West Circular Quay Public Domain Upgrade Works - Major Project 10_0104

Applicant Response to Submissions

7. Lighting

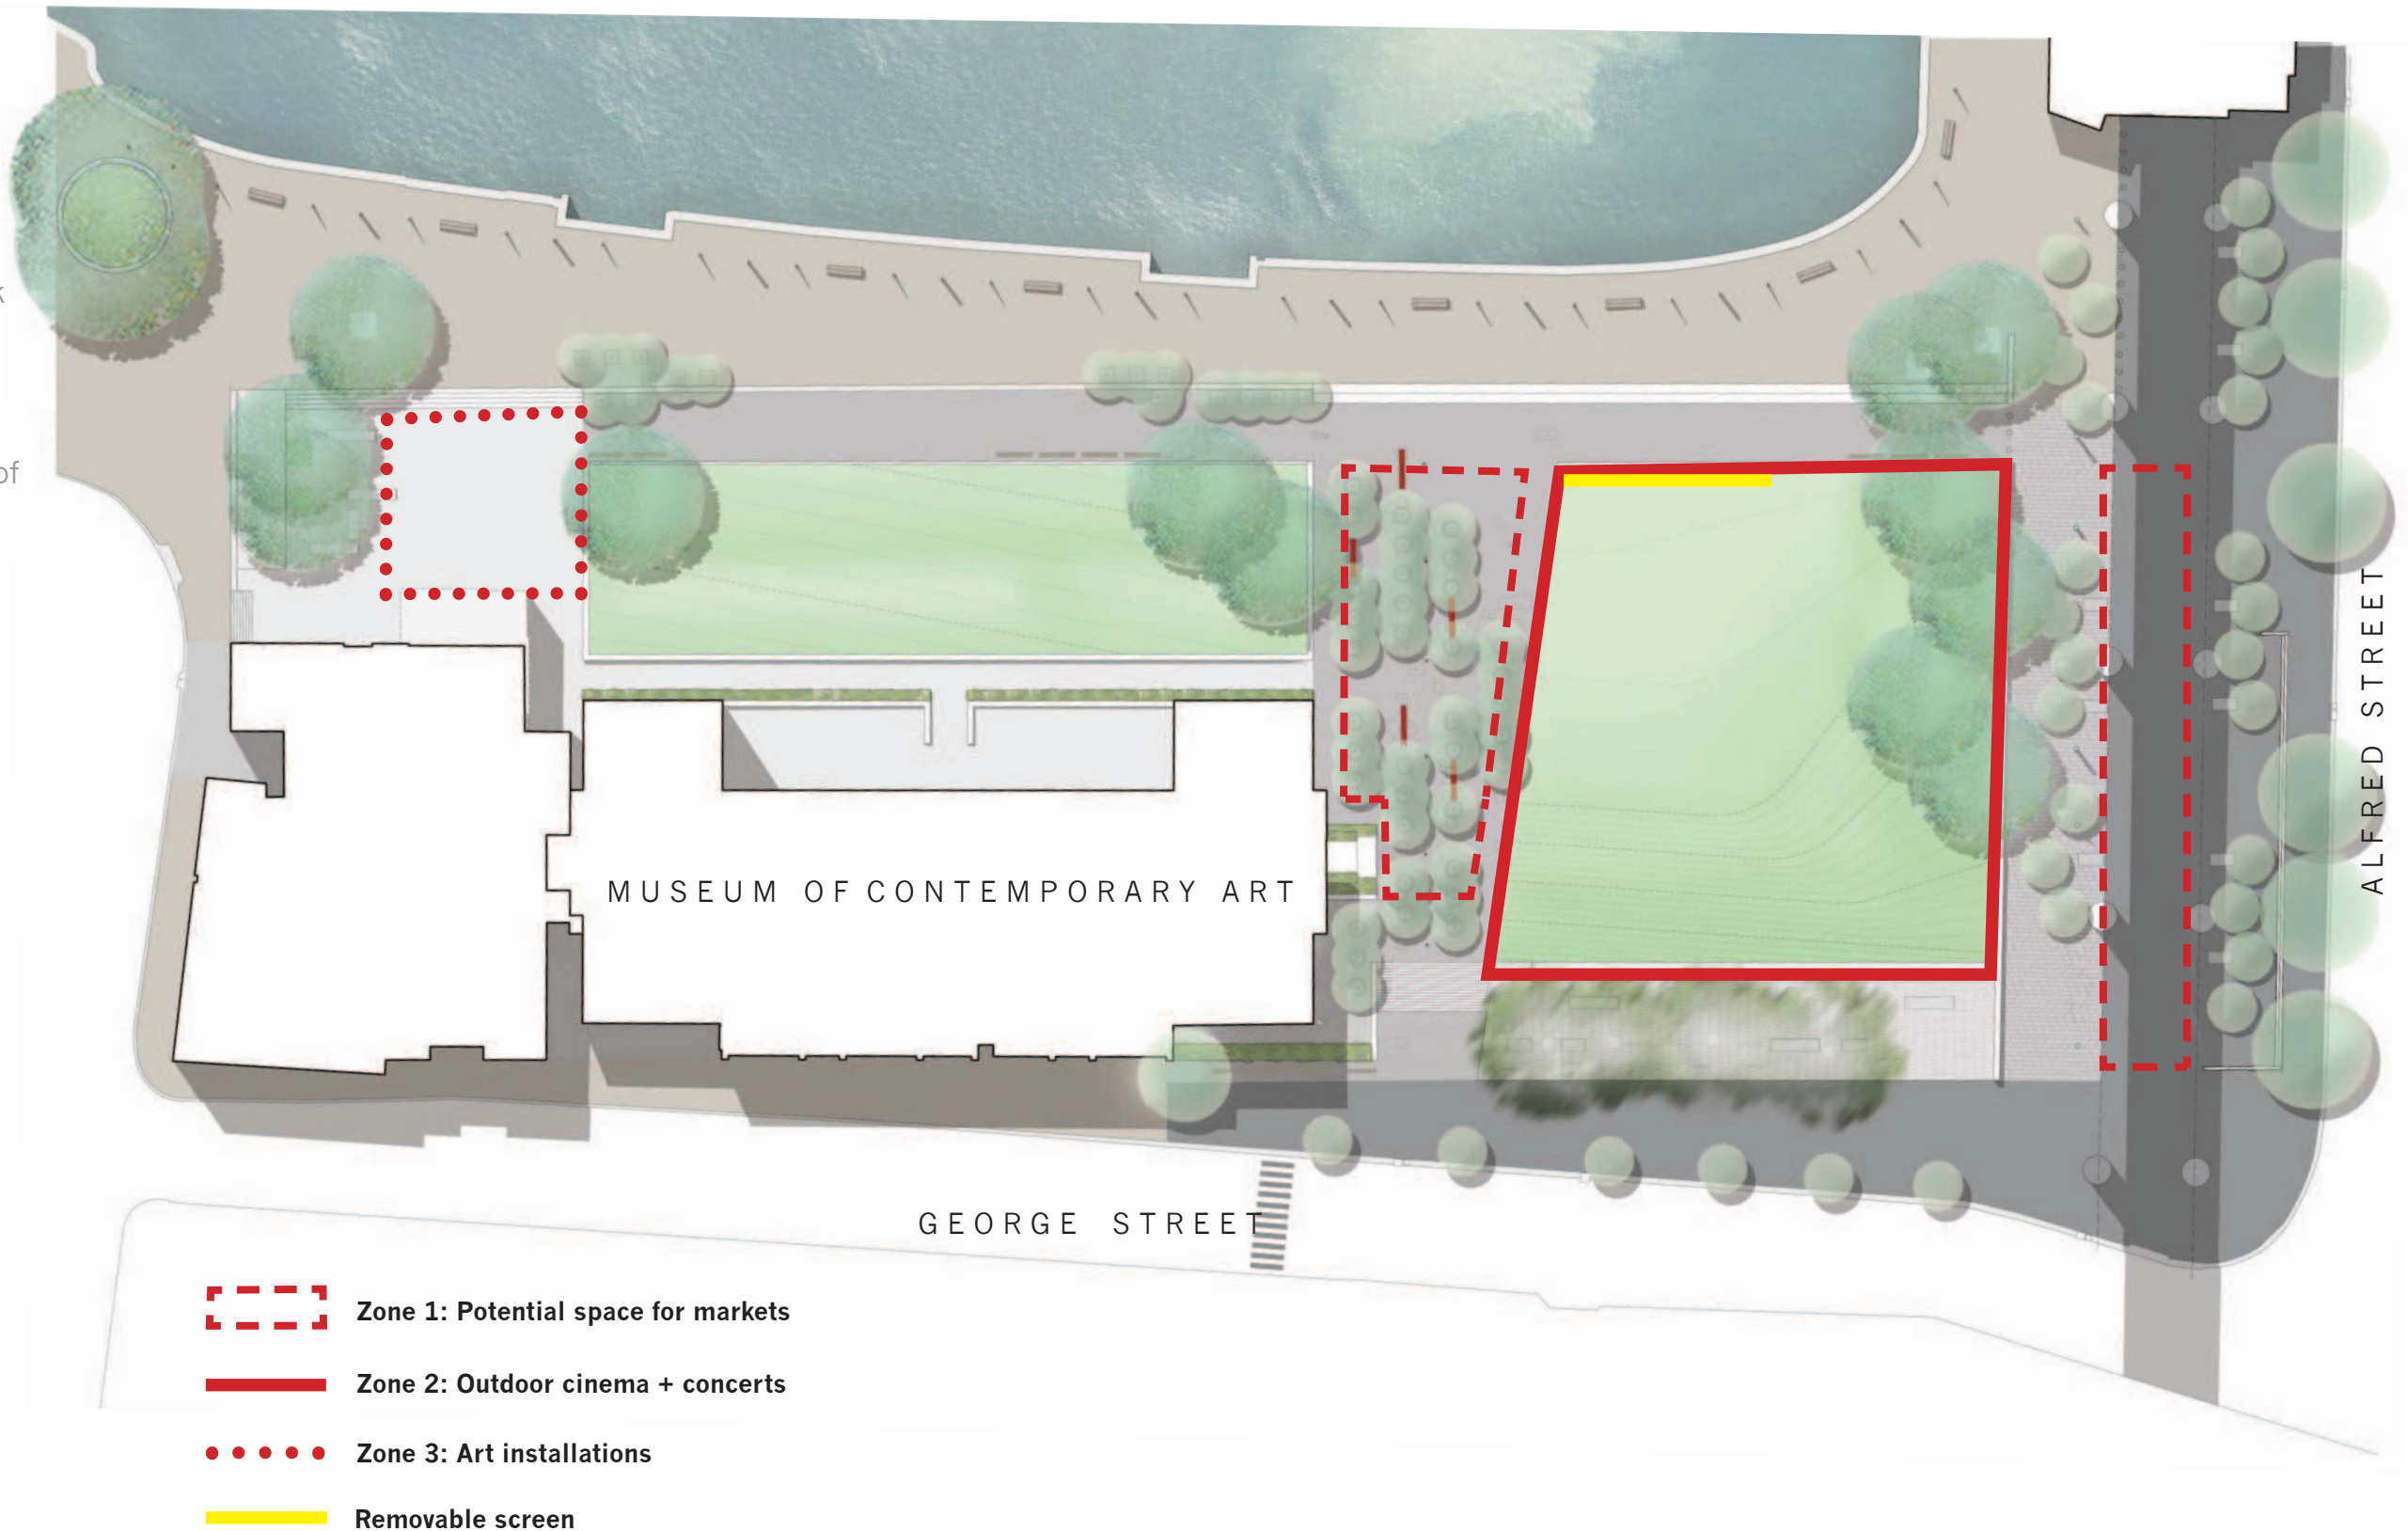
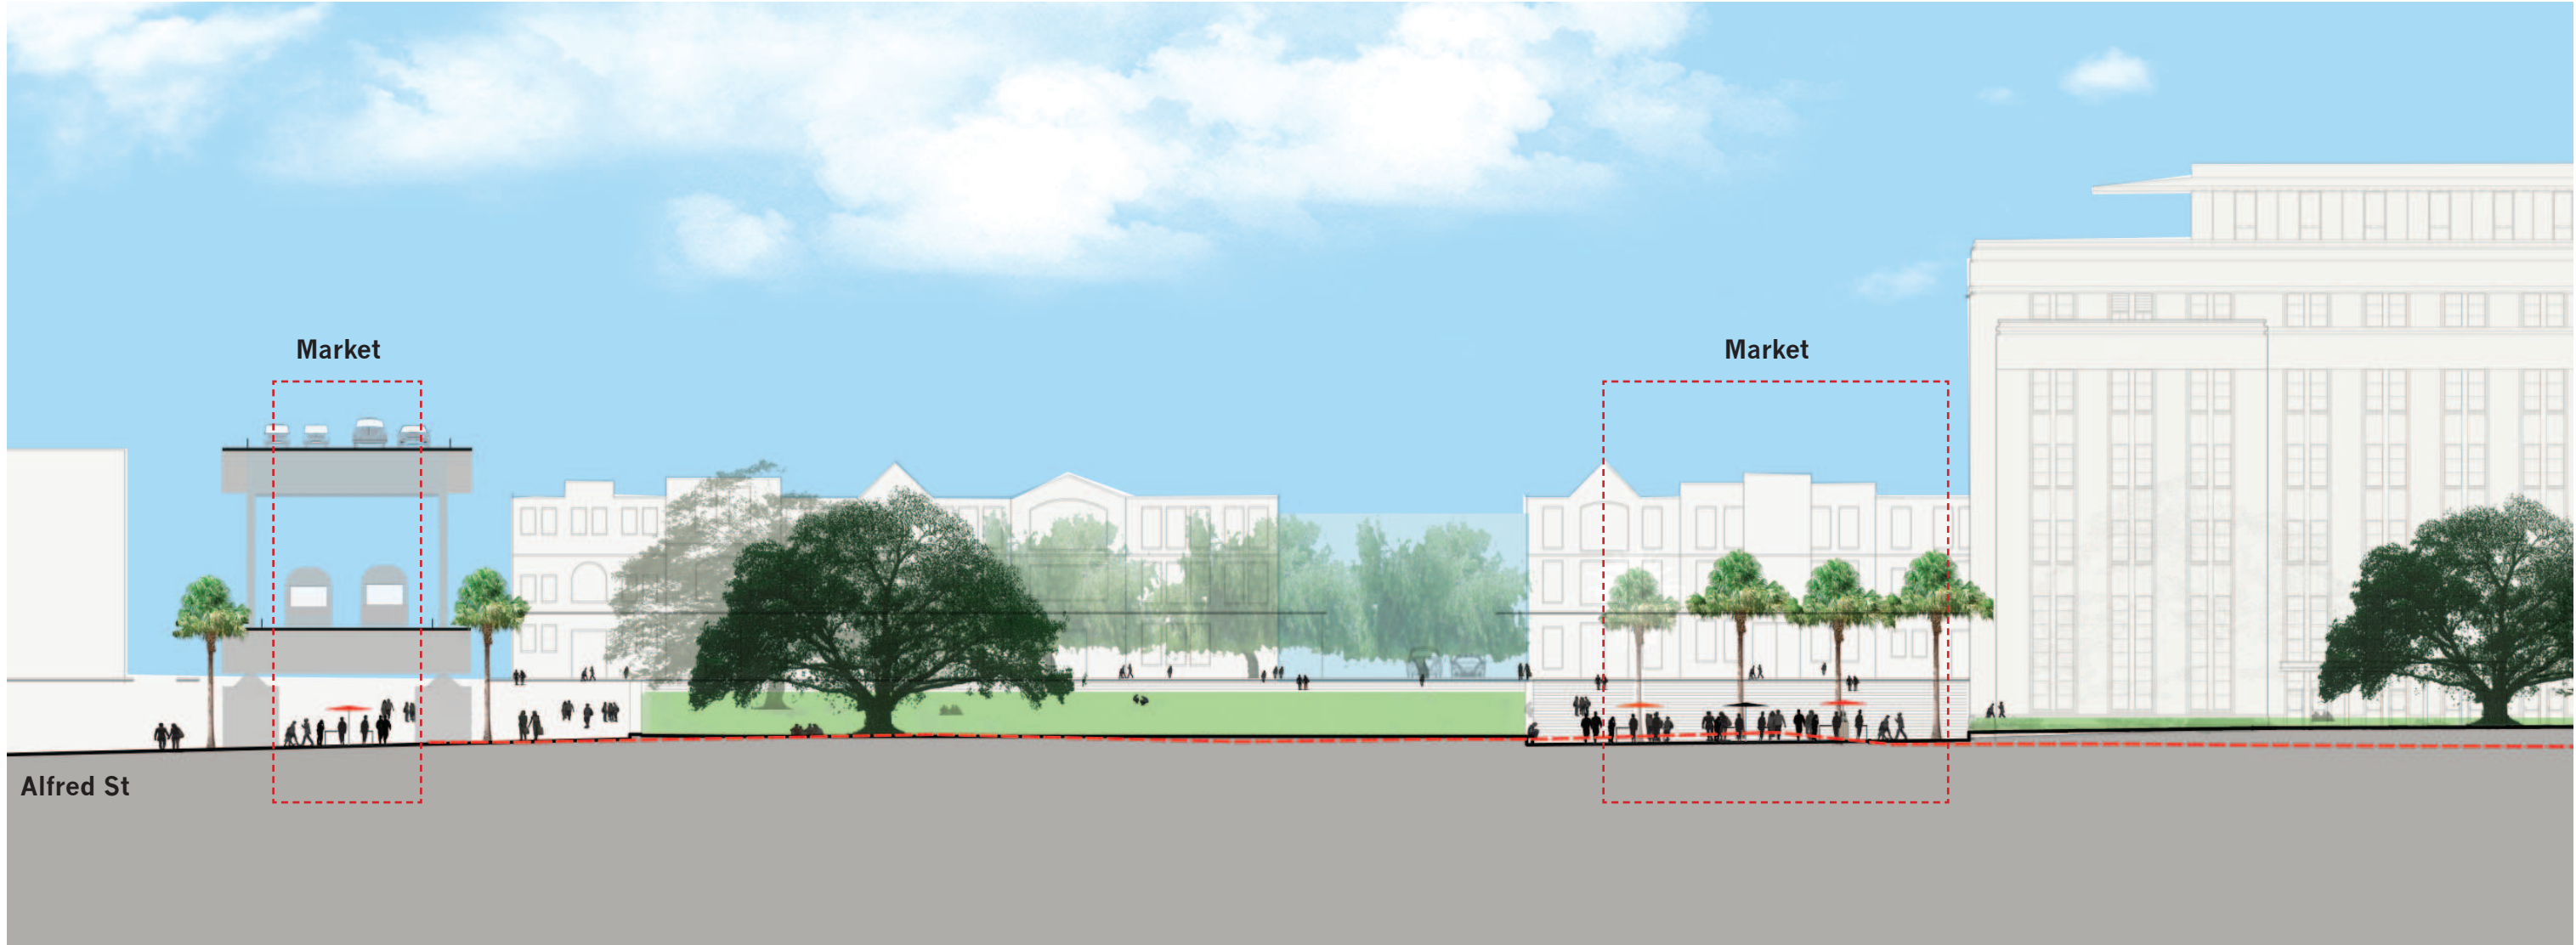
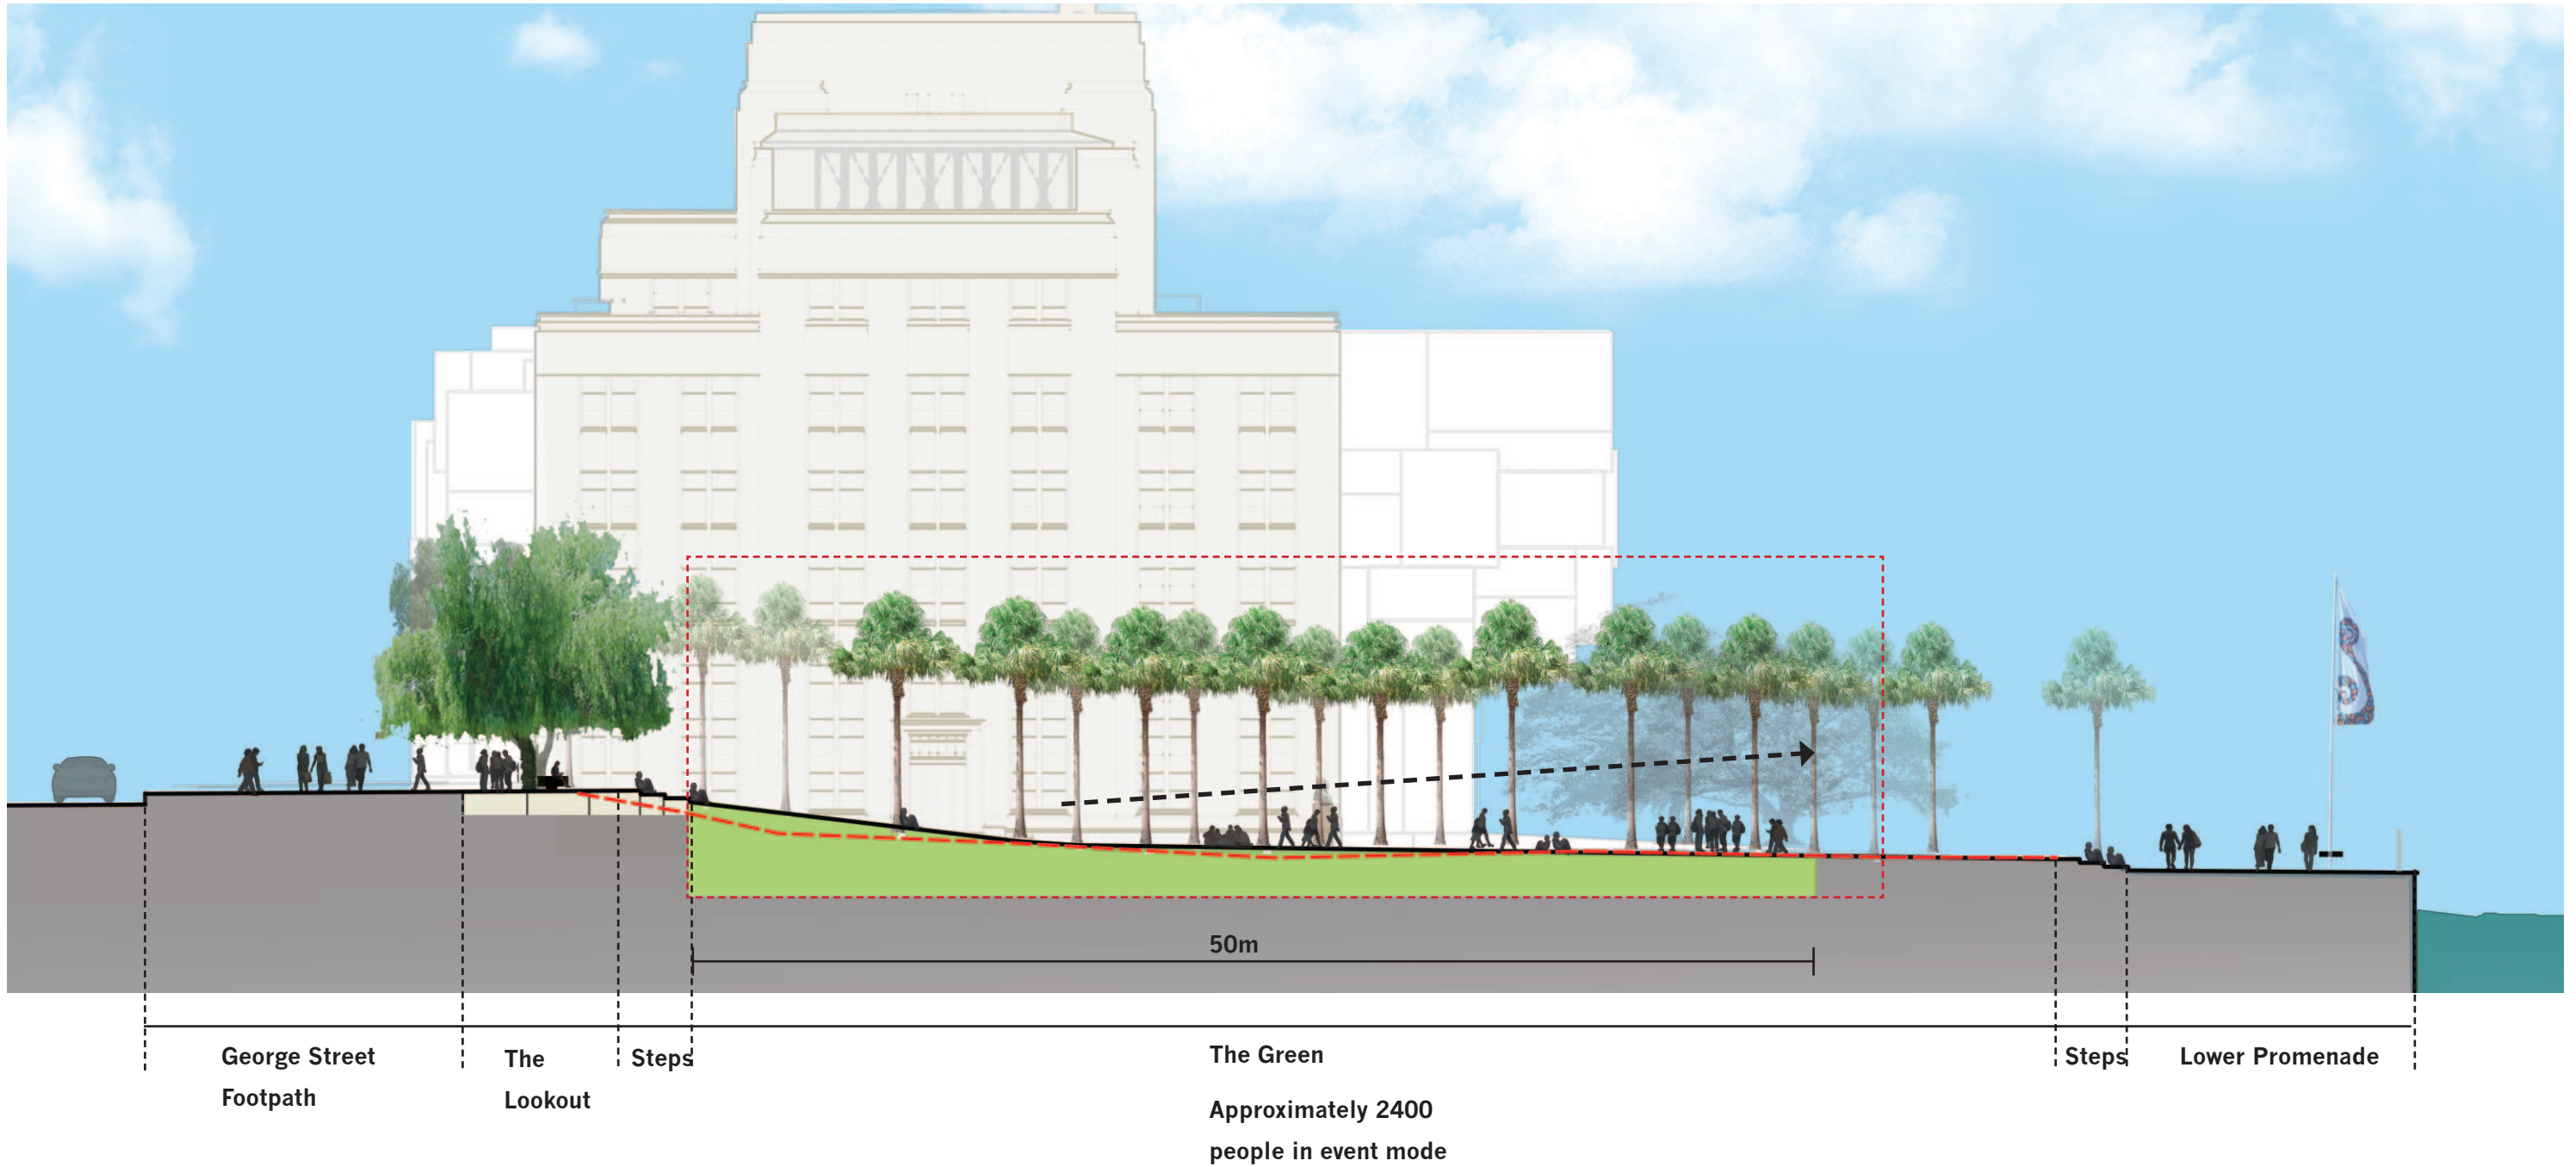
4. Lighting:	
a. The "sphere" type pole-mounted lighting design was not supported by Jørn Utzon for use around the Opera House and should not be continued.	The Project lighting is based on a consistent upgrade of existing foreshore luminaires (from <i>Macquarie</i> to <i>Bennelong</i> lights) along the foreshore south of Argyle Street/OPT.

b. The cost of the entire lighting scheme is potentially grossly underestimated and/or inadequate and should be re-evaluated.	The lighting cost refers to the replacement of the luminaires to the compliant <i>Bennelong</i> type fittings only. The Project does not include the relocation of light poles.

c. Insufficient details are provided about the type of light fitting in "Market Wharf".	Details are provided under Project Plan 7. <i>Lighting</i> and to EA report section 3.2 sub-section 8. <i>Provide lighting that fulfils the requirements of safety whilst allow for opportunities to enjoy the nighttime experience of key Harbour landmarks.</i>
